Our ref: NO/2023/115305/01-L01
Your ref: 3/2023/0069
Date: 02 June 2023

CHANGE OF USE OF LAND FOR THE TEMPORARY SITING OF ONE TWO-BED RESIDENTIAL CARAVAN AND ERECTION OF TWO MODULAR UNITS COMPRISING OF WORKSHOP AND STORE TO BE CLAD IN TIMBER. WETTERS BRIDGE PLANTATION, TWITTER LANE, WADDINGTON, BB7 3LG

Environment Agency position

Ground Floor Plan
600mm above finished ground level

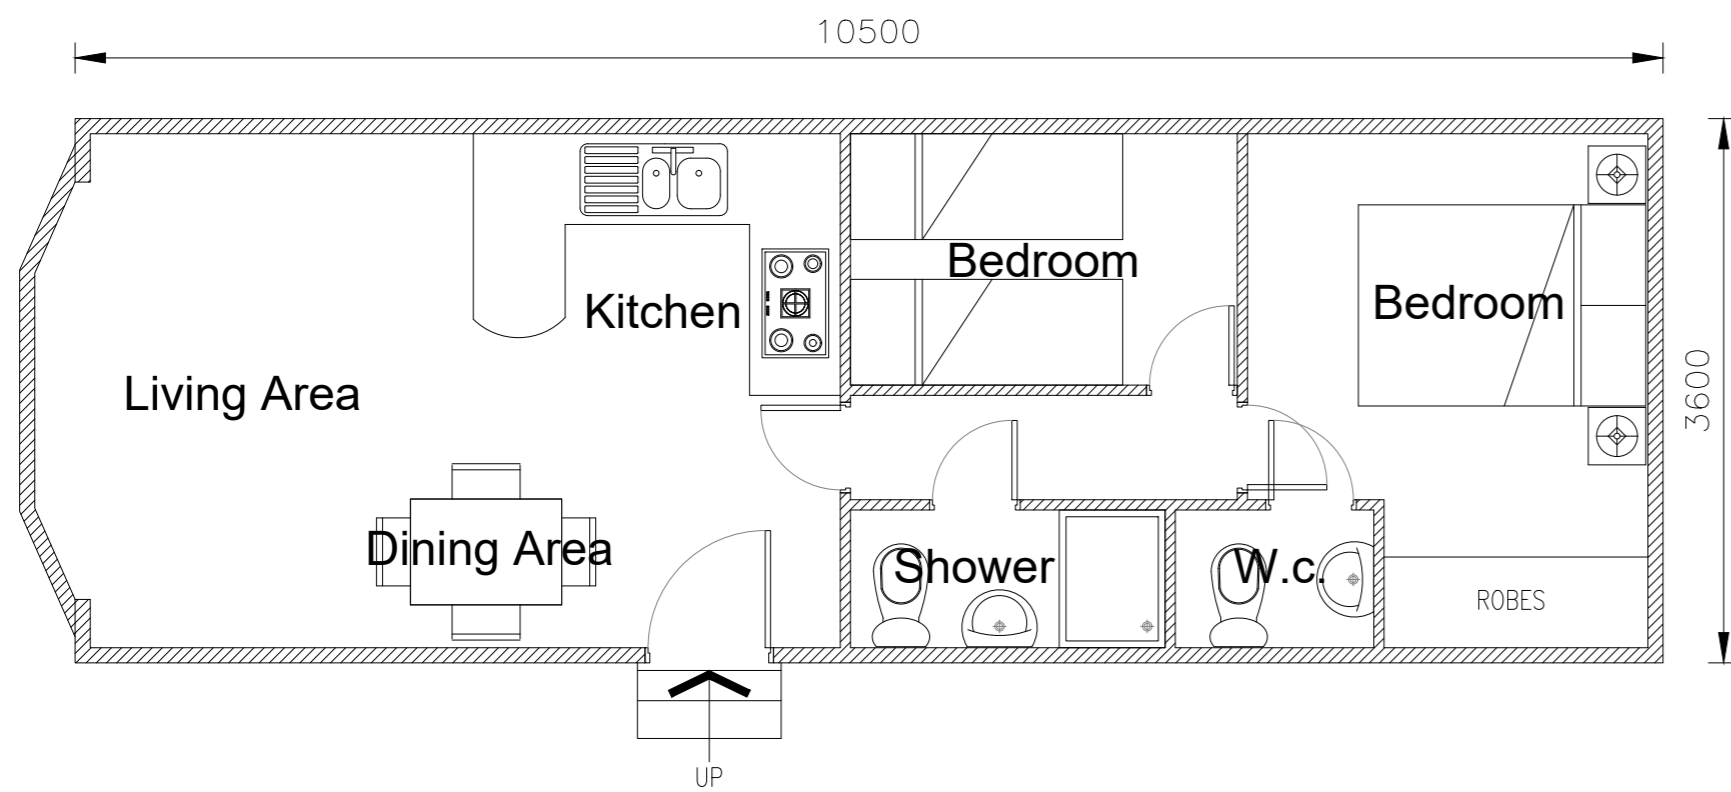
The proposed siting of the caravan, which represents the 'more vulnerable' aspect of the development, is within the area of the site at lesser flood risk and has access to land and the public highway that is at little or no risk of flooding. Through a combination of sequential siting of the caravan and by raising the level of the caravan a minimum of 600 mm above the existing ground level, the development should be safe.

The proposed development must proceed in strict accordance with this FRA and the mitigation measures identified as it will form part of any subsequent planning approval. Any proposed changes to the approved FRA and / or the mitigation measures identified will require the submission of a revised FRA.
